## **Application by RWE Renewables UK Solar and Storage Limited for the Byers Gill Solar Farm**

### **The Examining Authority's written questions and requests for information (ExQ3)**

**Issued on 20 December 2024**

Drawing Title
**ES Figure 2.10
 Typical transformer, inverter and
 BESS arrangement**

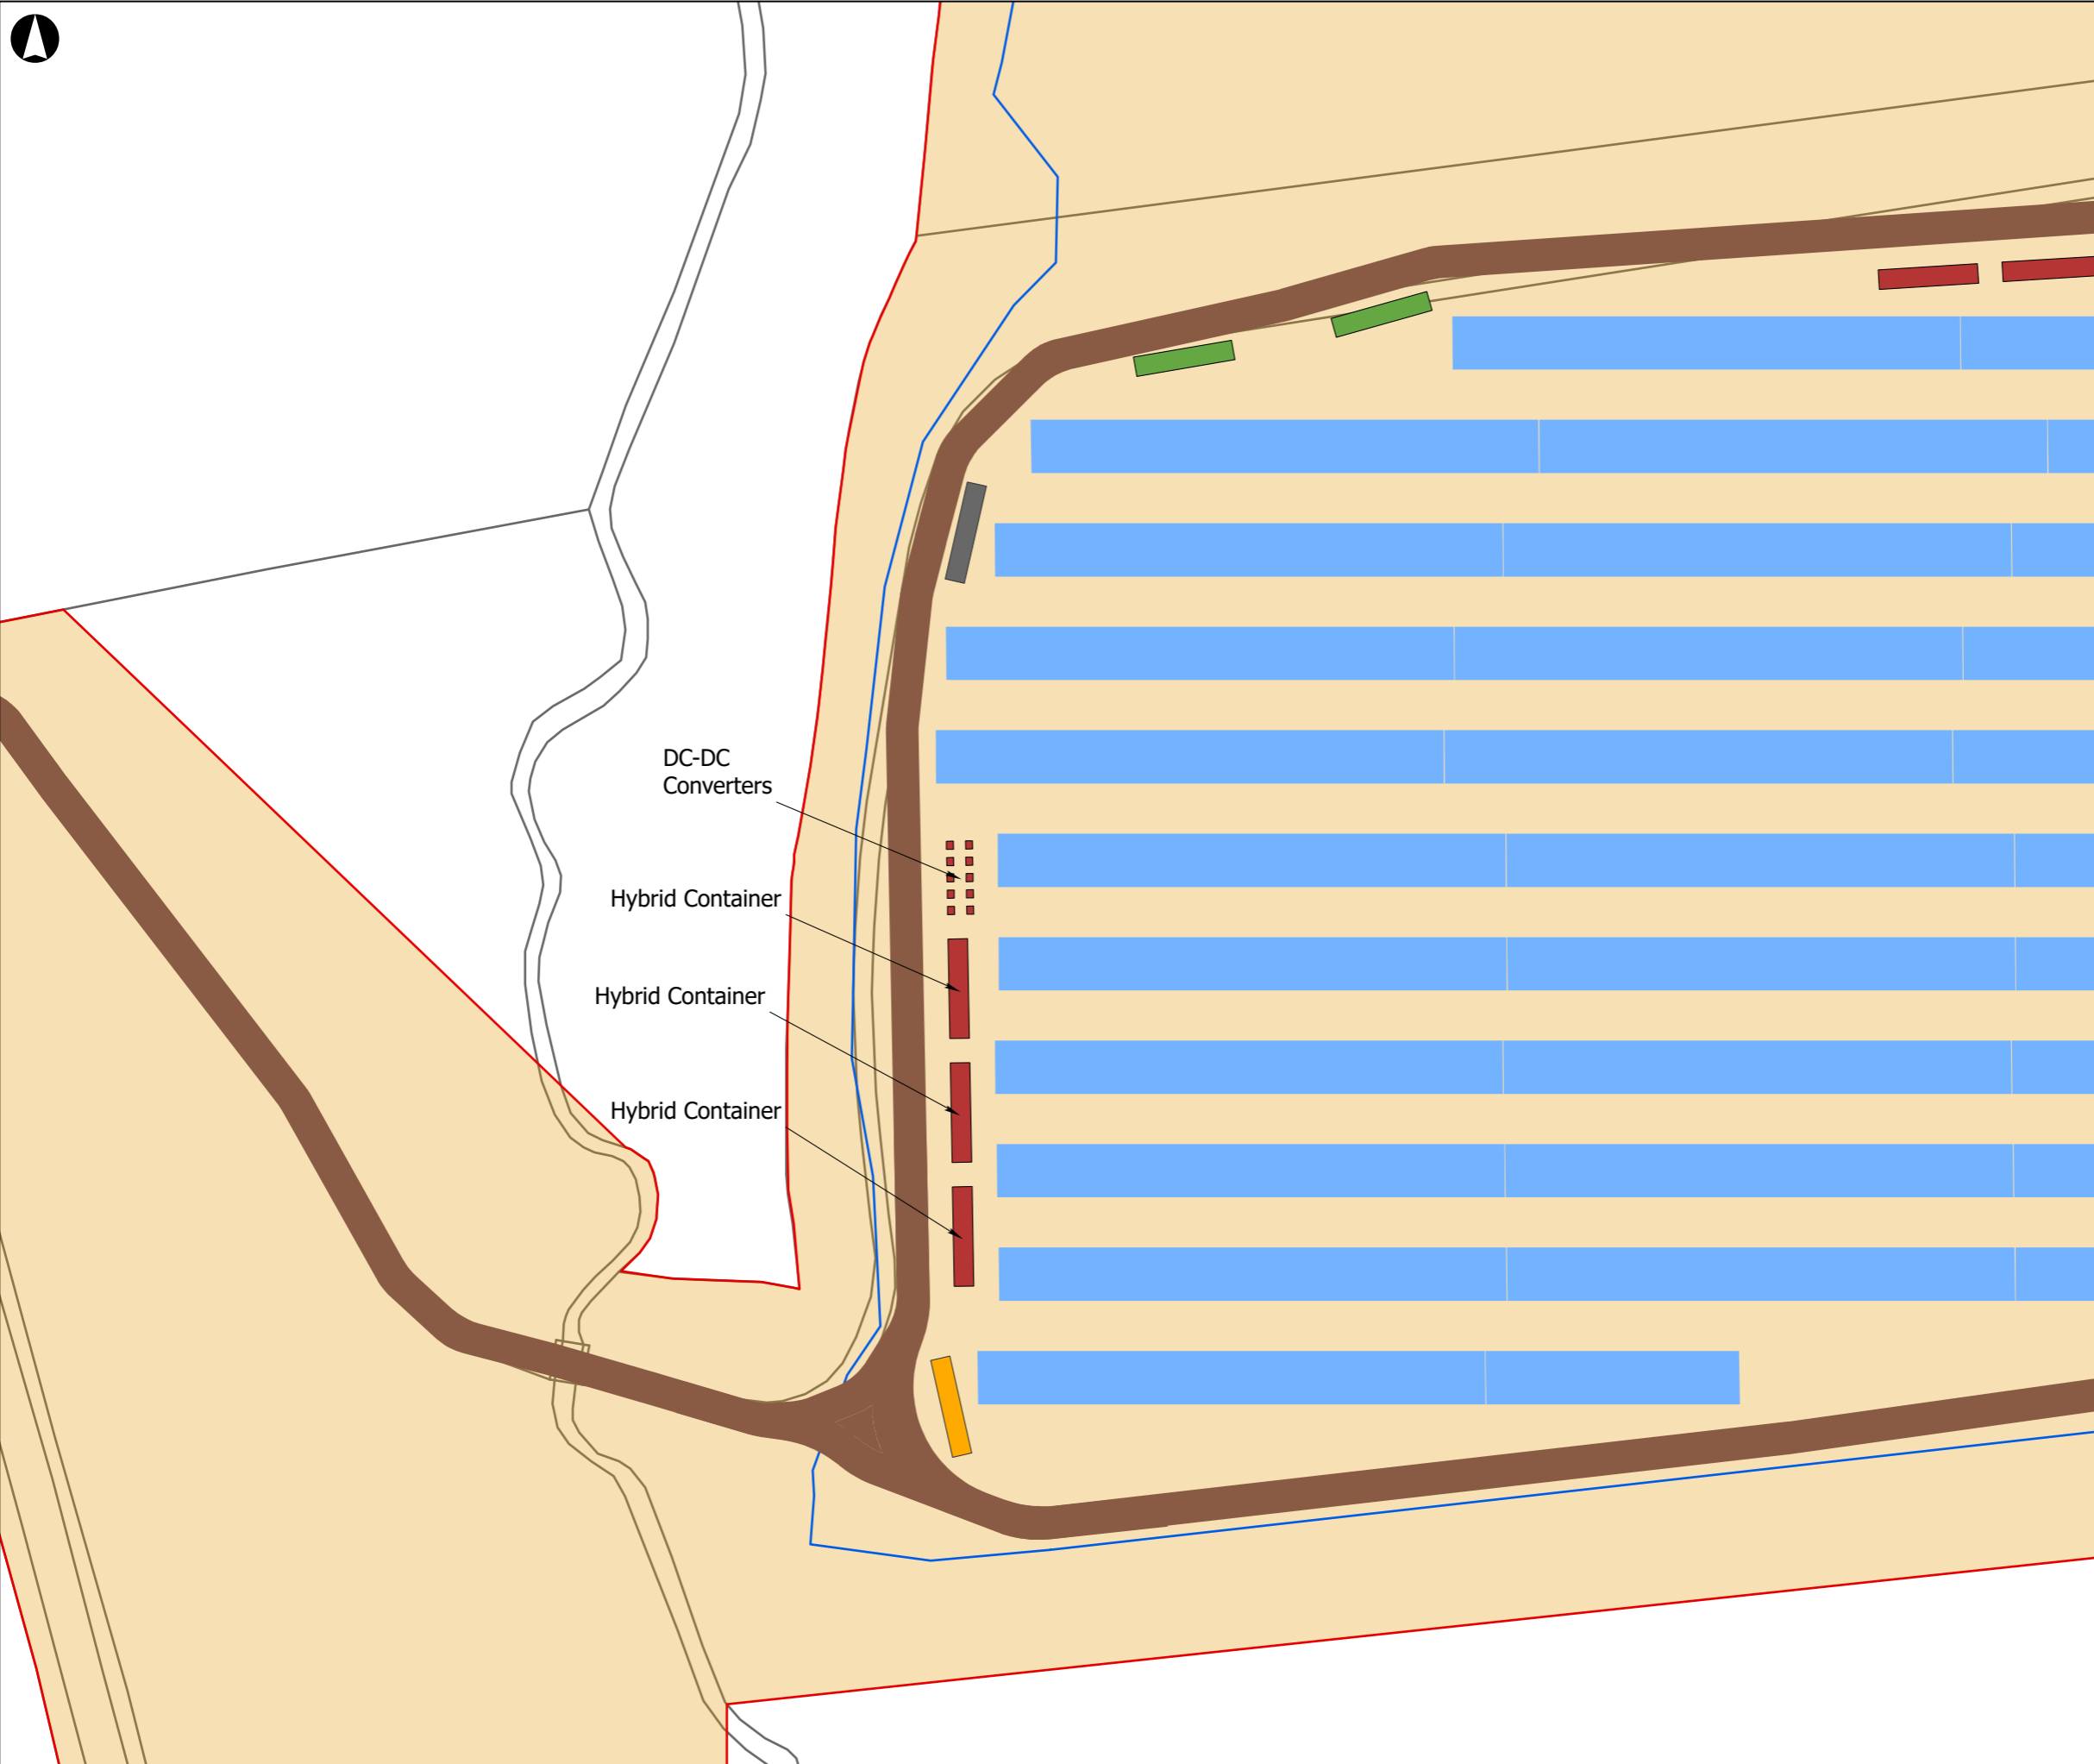
DES.3.2	Applicant	Paragraph 7.2 of Design Approach Document [REP5-025] also mentions that the Battery Energy Storage System (BESS) has been placed at least 300m from residential properties in the majority of cases, to reduce the visual and noise impact of the infrastructure. Can the Applicant confirm the areas where the BESS would be sited less than 300m from residential properties and what extra mitigations have been proposed to minimise the impact of such proximity of these areas or residential properties to the BESS?
DES.3.3	Applicant	The 1 <sup>st</sup> bullet point in paragraph 7.2,8 of Design Approach Document [REP5-025] states that inverters convert the DC generated by the solar PV modules into alternating current (AC) that can be exported to the national grid. Would the Applicant confirm if the DC-DC converter mentioned in the 3 <sup>rd</sup> bullet point of the same paragraph and annotated on Plate 7-3 should have read DC-AC converter?
